From: Ian Johnson [REDACTED]
Sent: 10 May 2017 15:56
To: Lucy Harding
Cc: [REDACTED] Ben Stephenson; Jonathan Quarrell; Jan Morton; Nicola Gooch; Paul Cranley; Peter Robinson | Western Design Architects
Subject: Y/1/17/OUT Land at Bonhams Field: Submission of Revised Indicative Layout Plan

RE: Land at Bonhams Farm, Site visit

CLIENT	
Seaward Properties Ltd	
PROJECT	
Bonhams Field	
DRAWING TITLE	
Sketch Layout	
DRAWN BY	CHECKED BY
PR	MW
DATE	09.08.16
SCALE	JOB NO.
1:500@A1	1617002
DRAWING NO	REVISION
SK02	I
SKETCH SCHEME	
THIS DRAWING IS COPYRIGHT © Western Design Ltd 2016

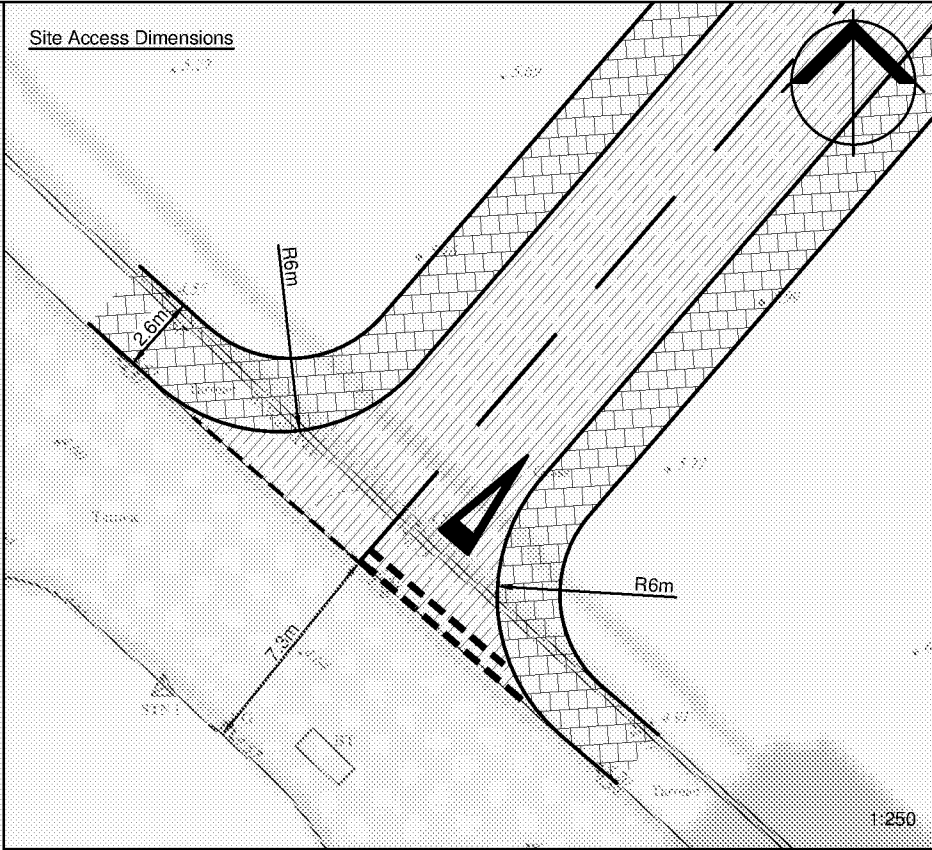
Thank you for your email and for the two options put forward. As discussed at our meeting, the comments below are made with a view to mitigating potential harm should the scheme be approved in principle. I am afraid that it is not possible to suggest that there is no harm from the proposal as the scheme occupies two fields which contribute to the historic setting of the listed buildings and their relationship with the landscape.

Notwithstanding this it was very helpful to see the two options which differ in the addition of a pair of houses on the main road. The reduction to two houses here, as from the terrace discussed, does work better in that it continues the building line along the main road but does not bridge the gap to the barn. My concern with a more open gap and the houses set back, is that the development could appear more isolated and less integrated into the existing built environment which is not your intention. The houses do

Turning to the main development itself, this has two very different characters. The barns which occupy the smaller field reflect neighbouring agricultural buildings in terms of typology and to this end bare some relation architecturally and spatially to the neighbouring Stakers Farm. How successful this might be still depends on a degree of detail which is not yet available to us. There are concerns that these dwellings will have individually laid out private gardens with tightly defined boundaries. This is likely to domesticate the setting which should be avoided. Some separation might be possible, but limited. Other design considerations would be the fenestration and elevations and the potential harm from features such as too many roof lights and solar panels.

In the main field we discussed the creation of a buffer zone to the north of Bonham's Farm and Barn. This is certainly an improvement on the previous proposal in terms of their close setting and provides some screening.

The main development beyond this to the north remains the most difficult aspect of the scheme. Whilst the pair of houses address the main road and continue an existing building line and the barns correspond with a neighbouring farm group, the main housing and its layout does not have the same reference points and therefore is more difficult to ground within the existing environment. The major concern here is the potential for this to appear overtly suburban or incongruous and therefore harmful to setting. The layout and landscape treatment are of course vital to this as are the number of houses proposed.

It is often the case that in new developments roads often tend to twist and bend to accommodate the density of houses sought, along with parking and garages. The road form therefore can develop a different character as it works for the housing layout in a specific way. This is not always a negative thing in itself, though can be difficult when trying to make a development appear natural and 'organic'. The provision and layout of parking spaces can also be problematic, especially if they are directly in front of houses where the front garden should be, or in the form of bays.

We did discuss the house designs and the need for an understated architecture. The cottage terrace Jonathan showed us was a good example of this. I appreciate that the images provided with the application are indicative, however the variation in roof profiles and material palette should avoid over complexity. Where house designs do vary, the doors, windows, chimney design, pointing and boundary treatments should also be different in small ways. A proliferation of close-boarded fences would also be an issue, as again, these are largely suburban treatments.

Further to Dr Wightman's email this morning please find attached our revised Indicative Layout Plan (Dwg ref. **SK 02 N**), which supersedes the previously submitted version (Dwg ref. SK 02 I). It is good news that we are in agreement with Dr Wightman that design details are a reserve matters consideration and are not related to the 'principle' of development.

Further to our site meeting on Thursday please see two alternative layout options which have responded to your concerns over the proximity of some proposed dwellings to the listed buildings on the southern boundary and one option of removing buildings from the road frontage.

When on site we discussed relocating the southern block and a continuation of the community orchard, which you will see now connects both access points into the site to provide an amenity resource and green buffer to the heritage assets. Continuing along with this theme we have proposed an informal surface treatment for the path in the form of hoggin and a lighter shade of resin bonded gravel for the section of road that runs alongside the proposed orchard. This should also give a clear message to drivers of lower speeds rather than more traditional traffic calming measures. Please also note we have rotated the barn style properties, as we discussed on site.
